## About the application

Application number: 2020/92546	
What is the application for?:	Outline application for the development of up to 770 residential dwellings (Use
Address of the site or building:	Land off, Blackmoorfoot Road and Felks Street, Crosland Moor, Huddersfield, HD4 7AD
Postcode:

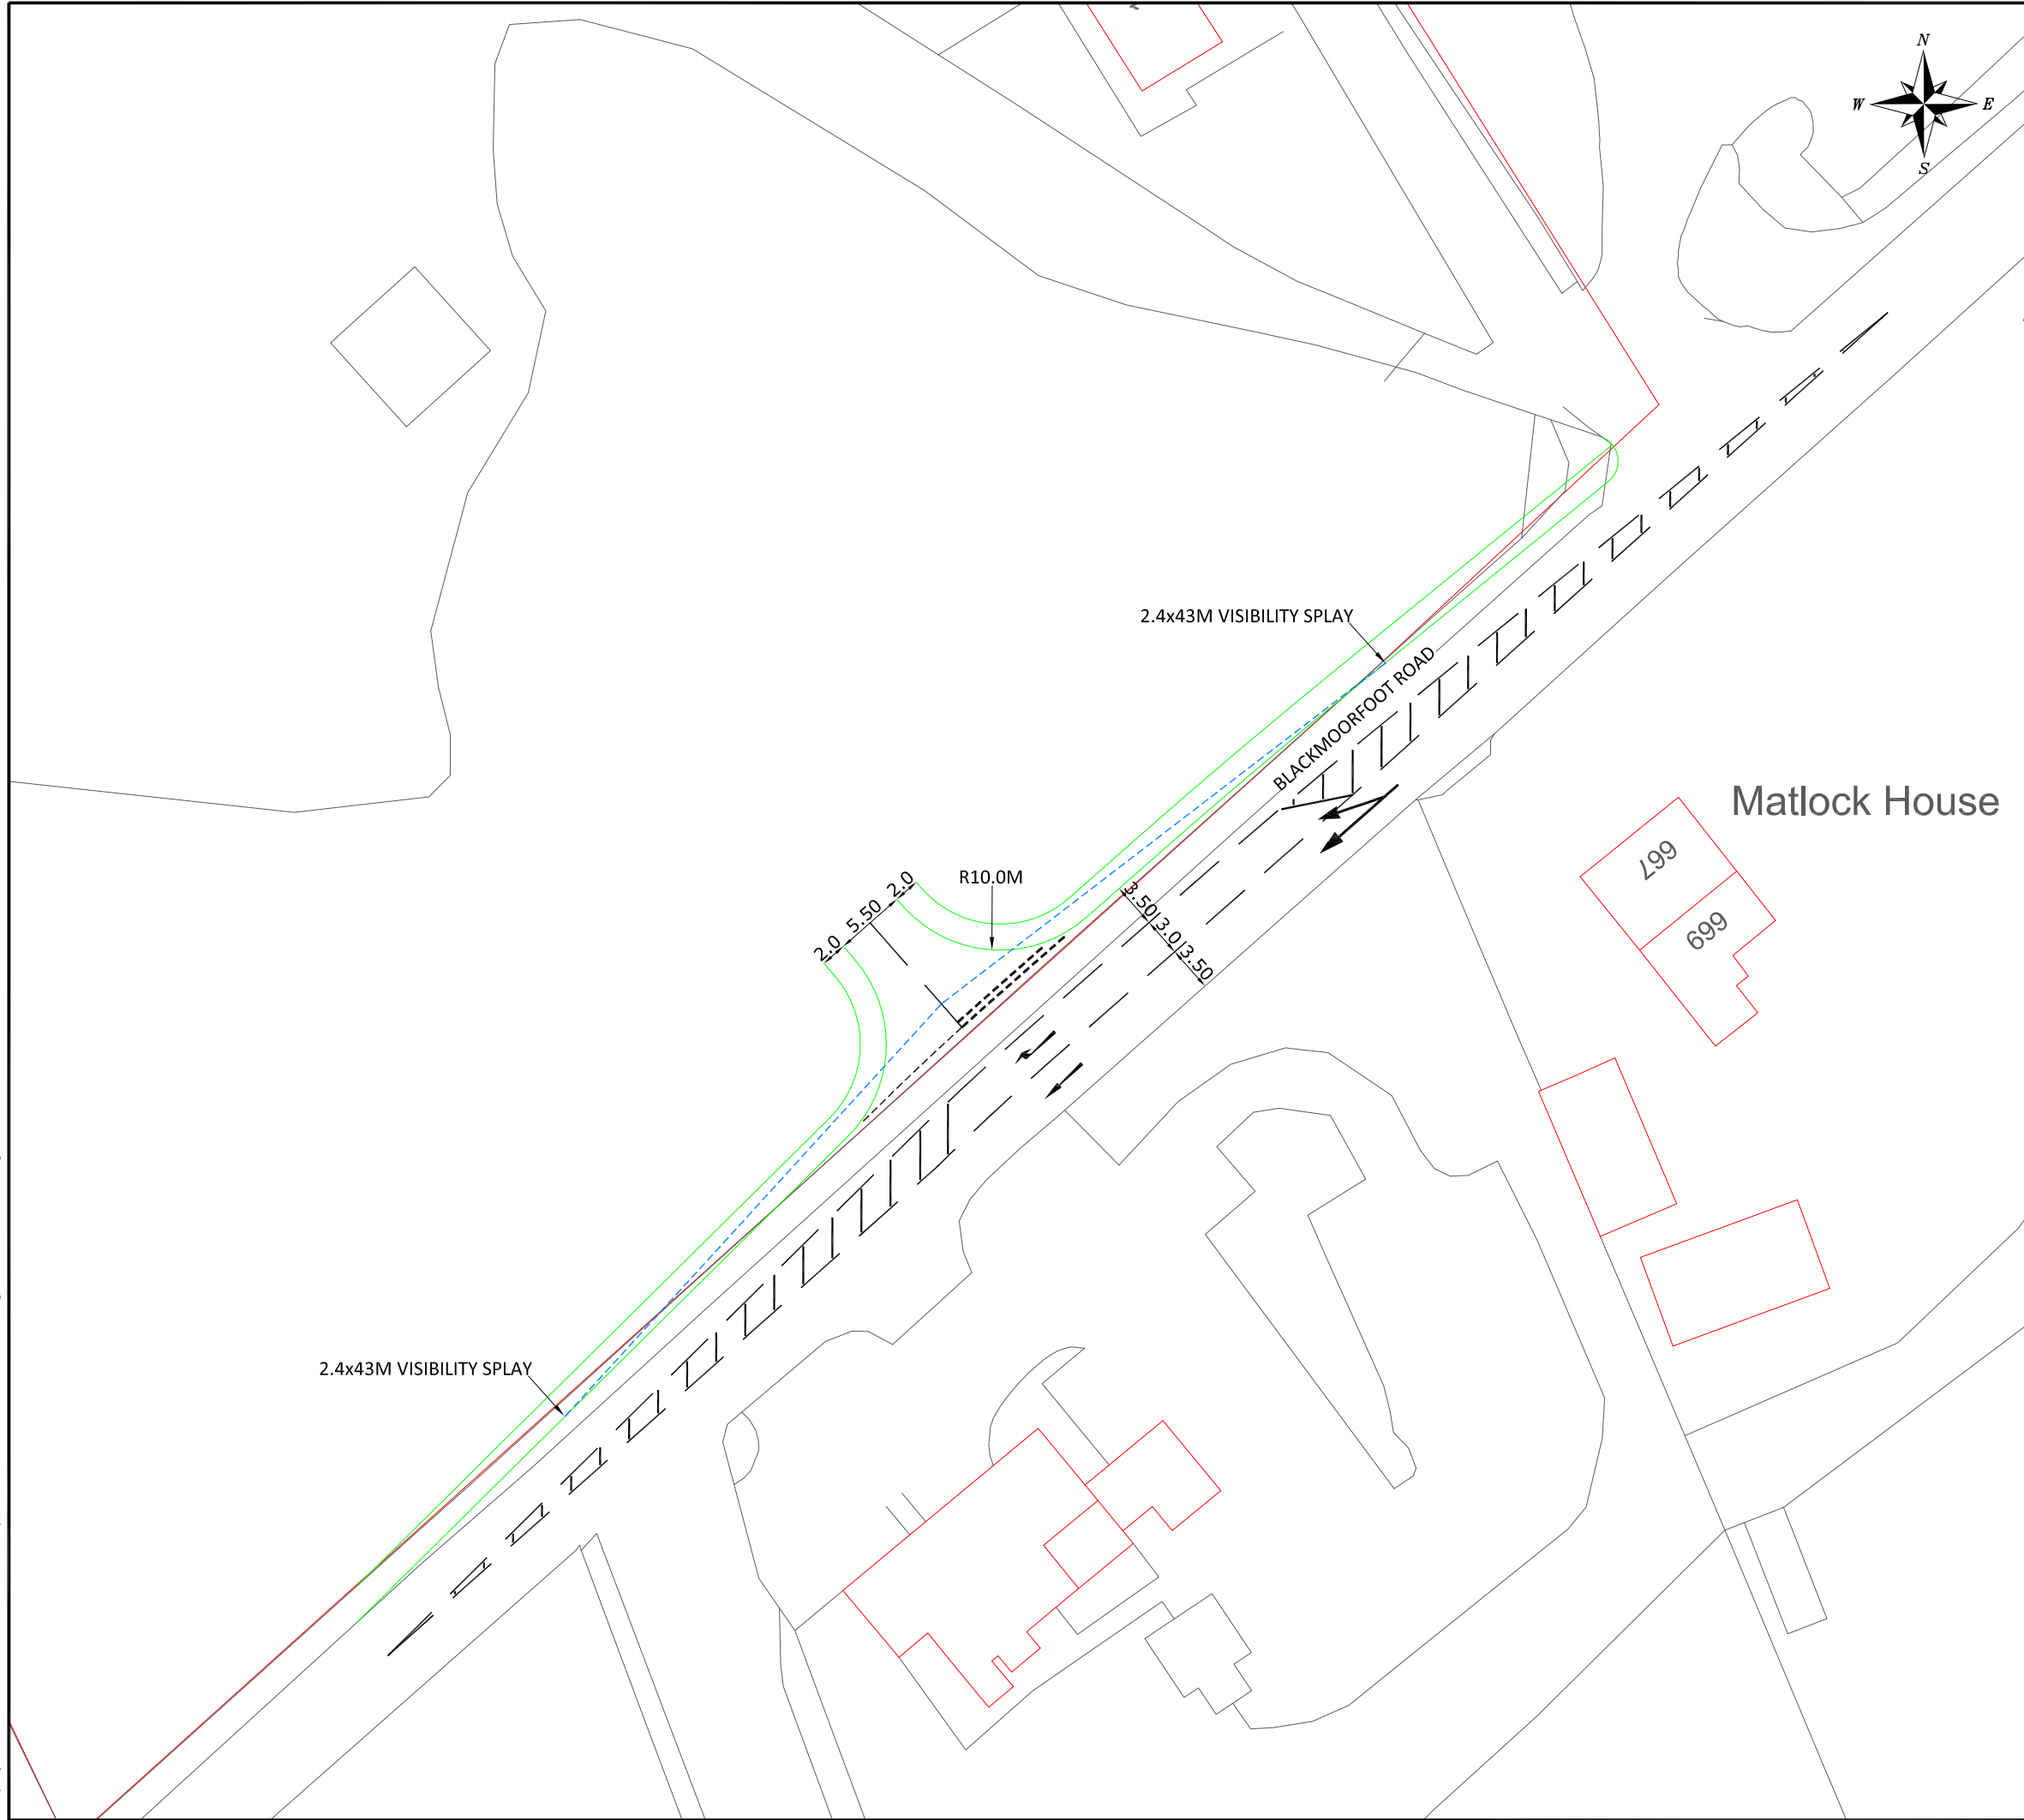
Type of comment: An objection
<p>As a long standing occupier of the property directly opposite the site i am concerned that the proposed siting of the entrance will not be as suitable as the report suggests .As many people may or may not know Blackmoorfoot Road is a 30mph speed limited road till past the left turn onto Sands House Lane then changing to a 40mph thereon after .At the previous consultation event i expressed my concerns that the proposed entrance was not suitable for this development as given the speed limit applicable on this road it is seldom adhered to with speeds in considerable excess of the national speed limit .My suggestion was that to make the site safer to access and to minimise dangerous overtaking either on or in the run up to the proposed entrance a more suitable and safer solution would be a roundabout which would be offset to the sands house lane junction and Blackmoorfoot road and would not require the purchase of any additional land as it would be incorporated onto the development site to make this a viable solution to safe and orderly entrance and exit to the site.It is inevitable that this huge project will be approved as it meets the criteria set out by KMC ,so it is imperative that the council officers make the correct stipulations regarding site access ,materials to be used, cycle lanes,suitable pedestrian access etc ,unlike St Luke's Hospital site who are building new houses in brick in a predominantly stone built housing area .</p>
